Please ask for: Nicola Moore
Email: nicola.moore@arun.gov.uk
Telephone: Ext 37944
Our Ref: WA/40/20/NMA
Your Ref:
Date: 24th June 2020

Application for a Non-Material Amendment Following a Grant of Planning Permission

Development: Non-material amendment following grant of WA/13/20/HH to change French doors and small window to bi-fold doors.
Location: 22 Henty Close Walberton BN18 0PW

Drawing No. 220/587/3

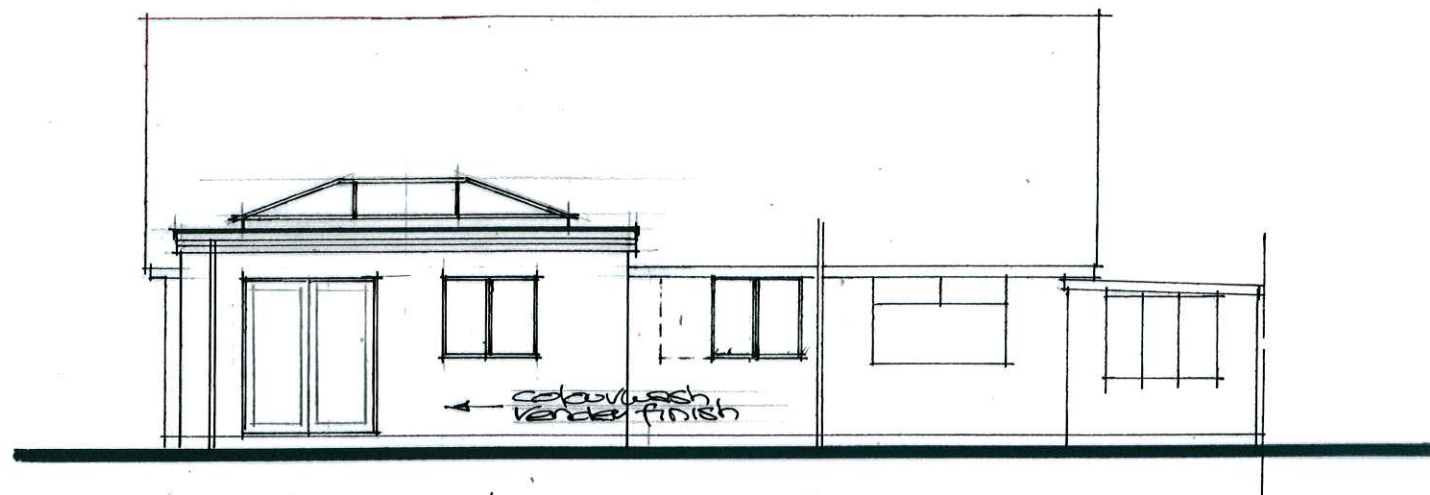
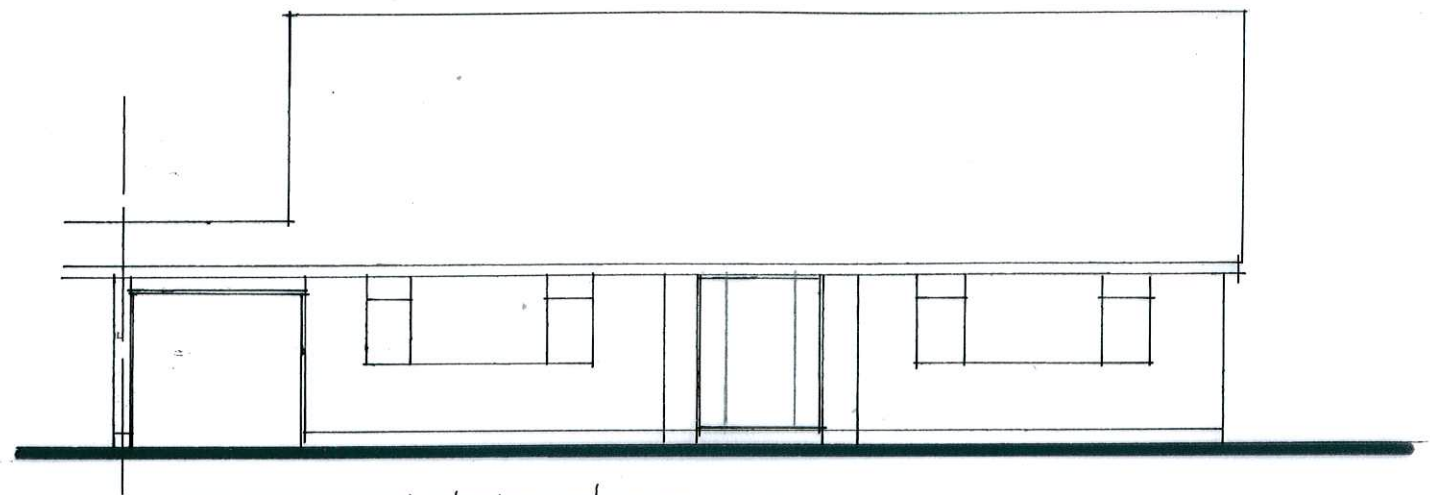
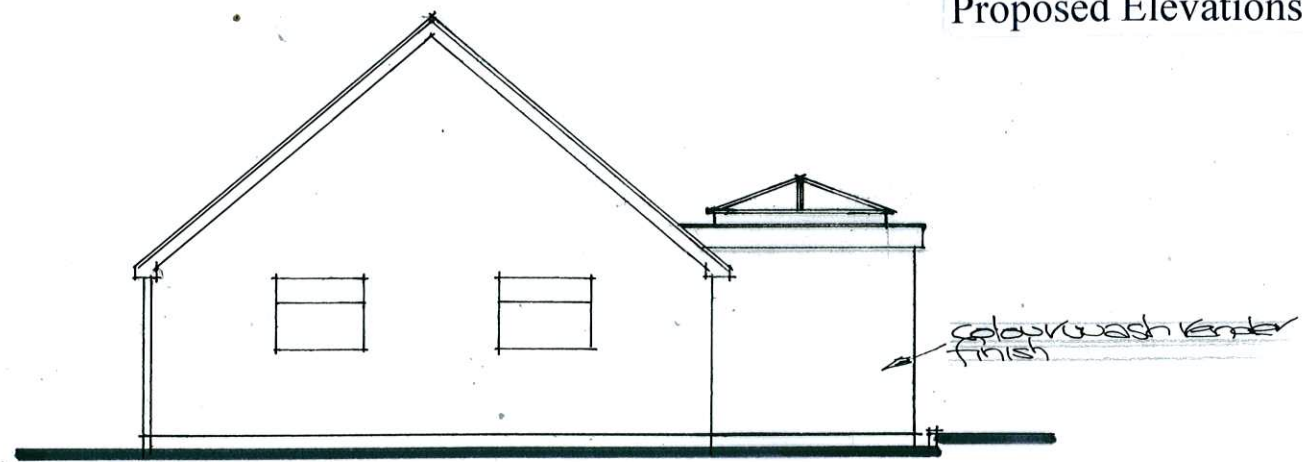
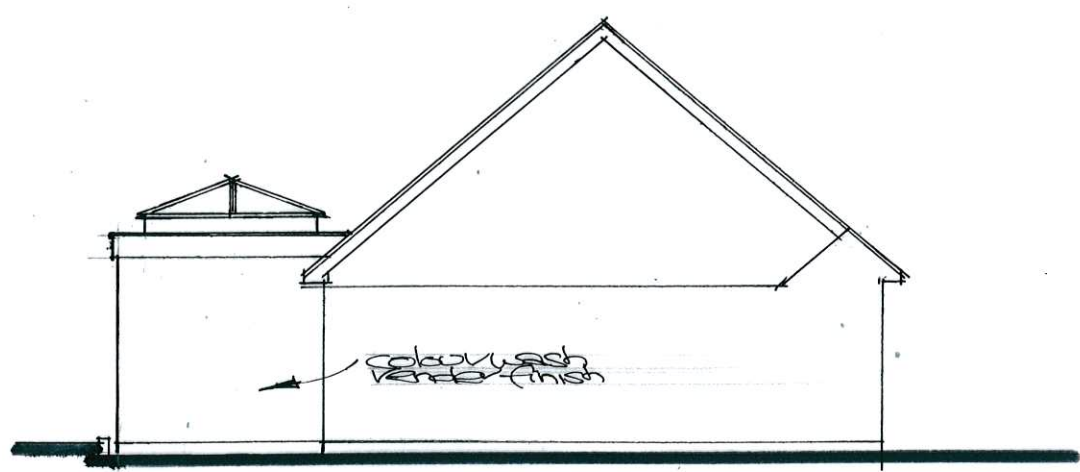
The new plan submitted BR/220/587/3A includes a dormer on the East elevation, but this is not shown on Dwg No 220/587/3. For clarity please confirm if the dormer is part of this application.
